CITY OF ALBUQUERQUE

October 11, 2022

Re: Champion Xpress
2100 Central Ave. NW
30-Day Temporary Certificate of Occupancy
Transportation Development Final Inspection
Architect's Stamp dated 4-25-22 (J13-D216)
Certification dated 10-03-22

PROJECT TITLE	CHAMPION XPRESS CARWASH	JOB NO.	2100 CENTRAL AVE, ALBUQUERQUE, NM 87104
PROJECT MANAGER		DRAWN BY:	
SHEET TITLE	ARCHITECTURAL SITE PLAN	Project Number

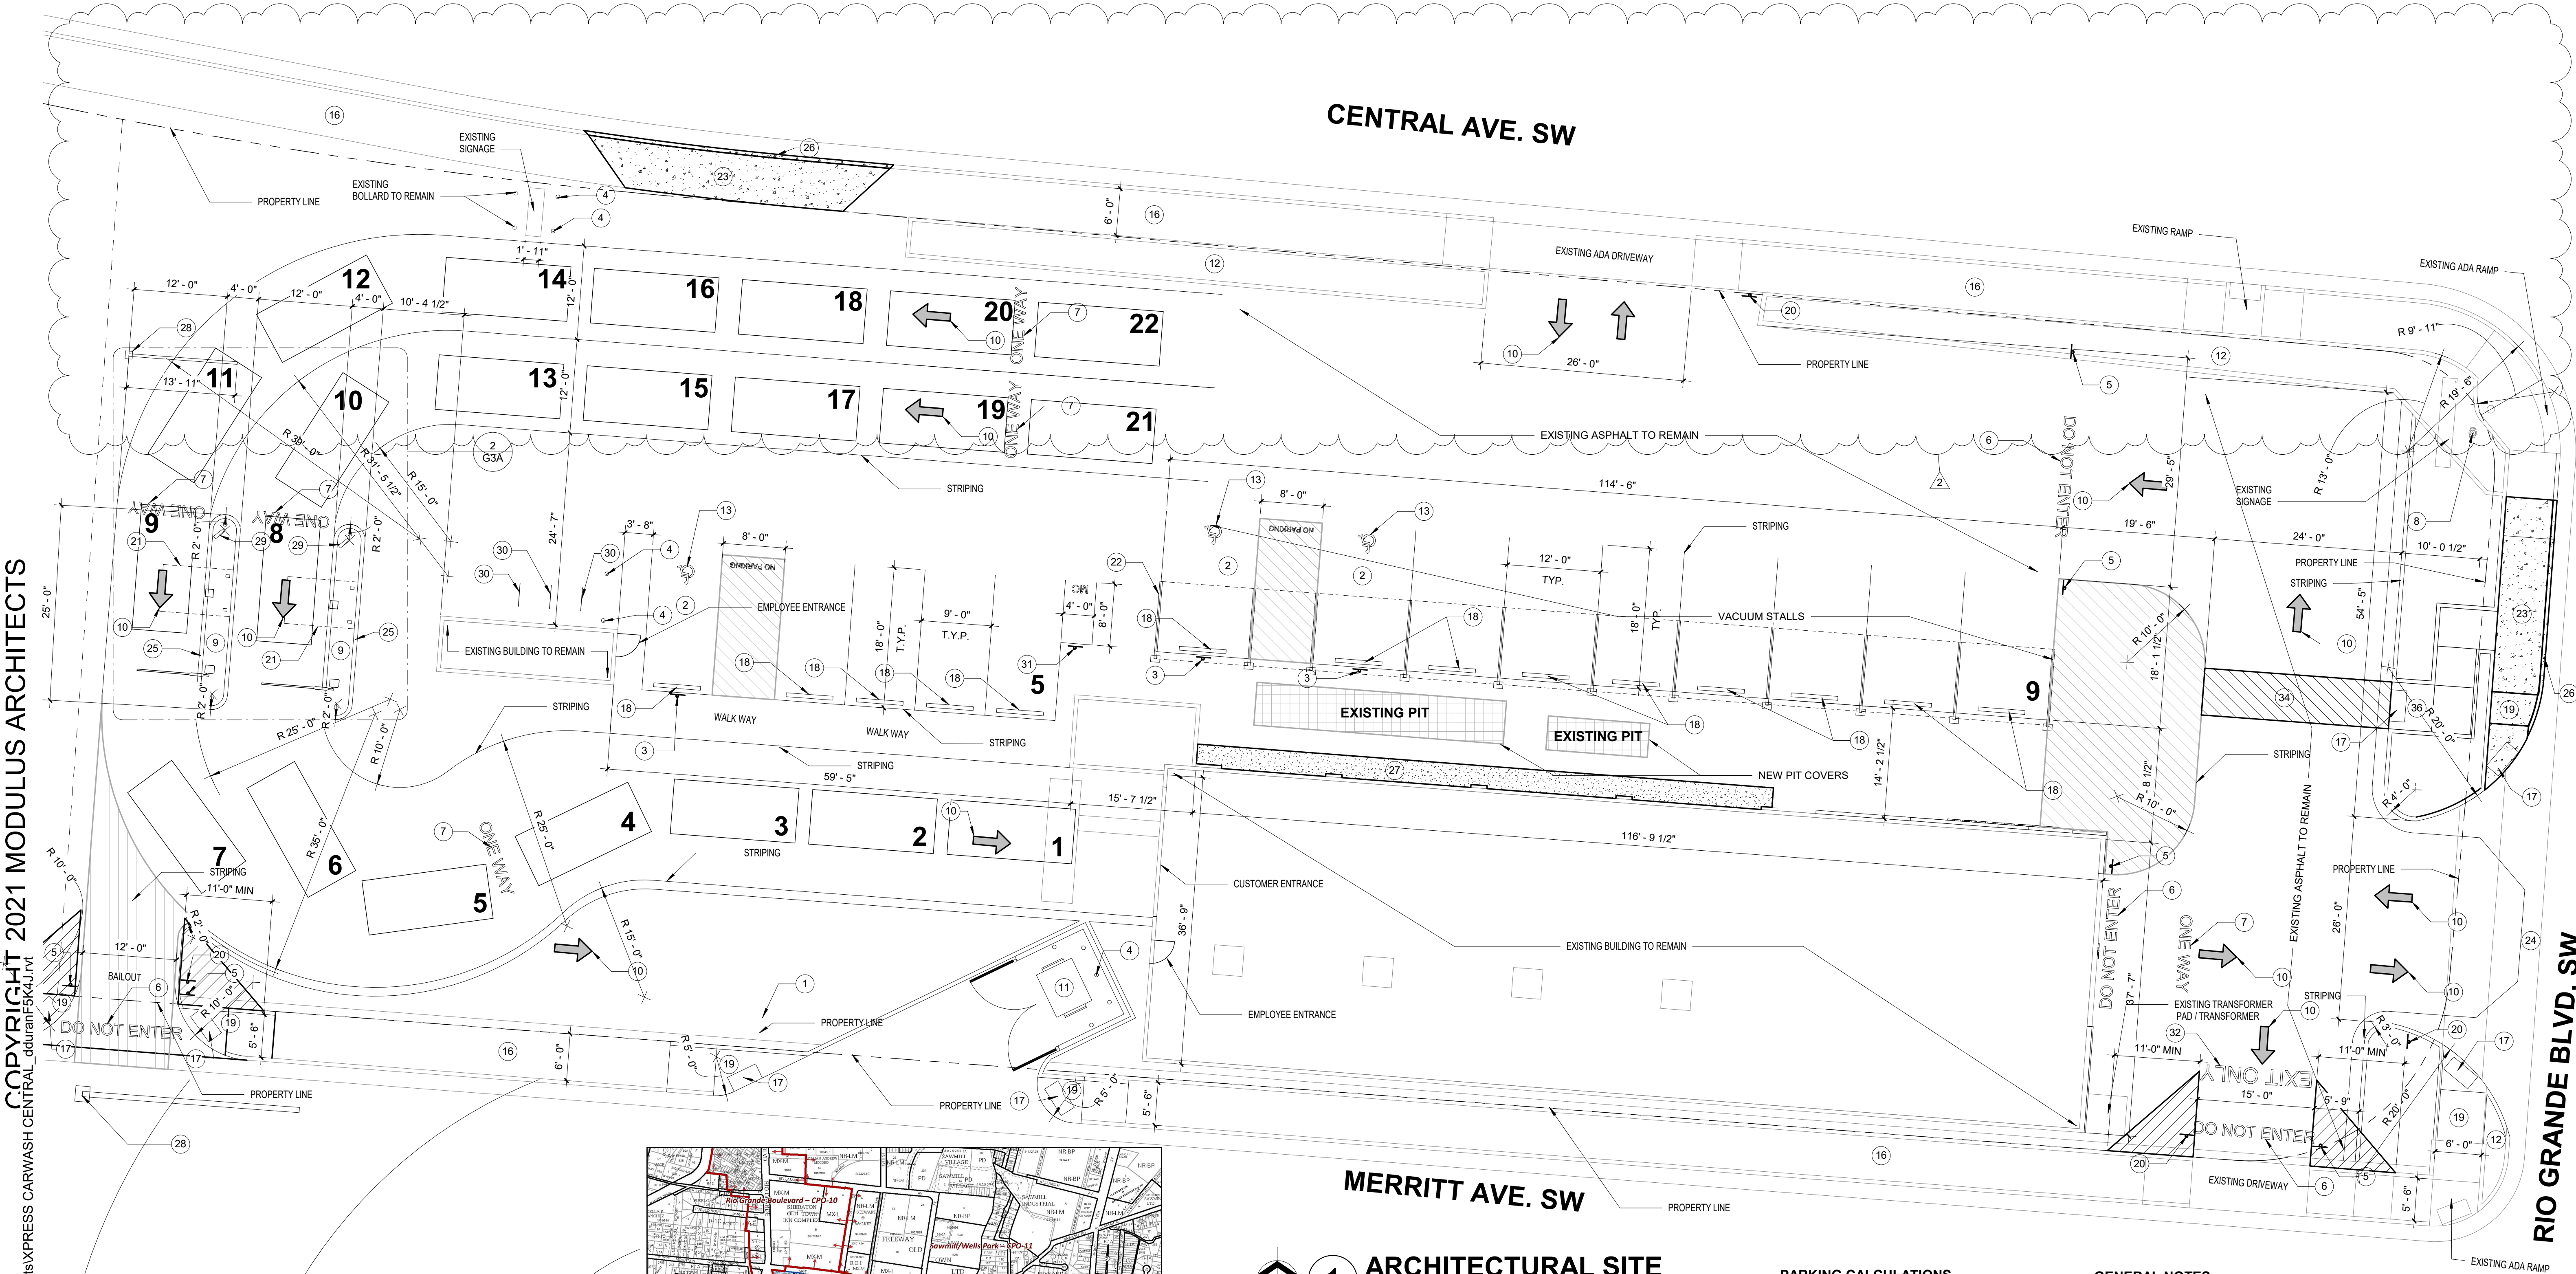
- Driveways accesses of Rio Grande Blvd. and Merritt Ave. need to be built per approved site plan (per COA std dwg 2426).
- The pavement marking "MC" should be shown in the opposite direction for motorcycles entering the parking space.
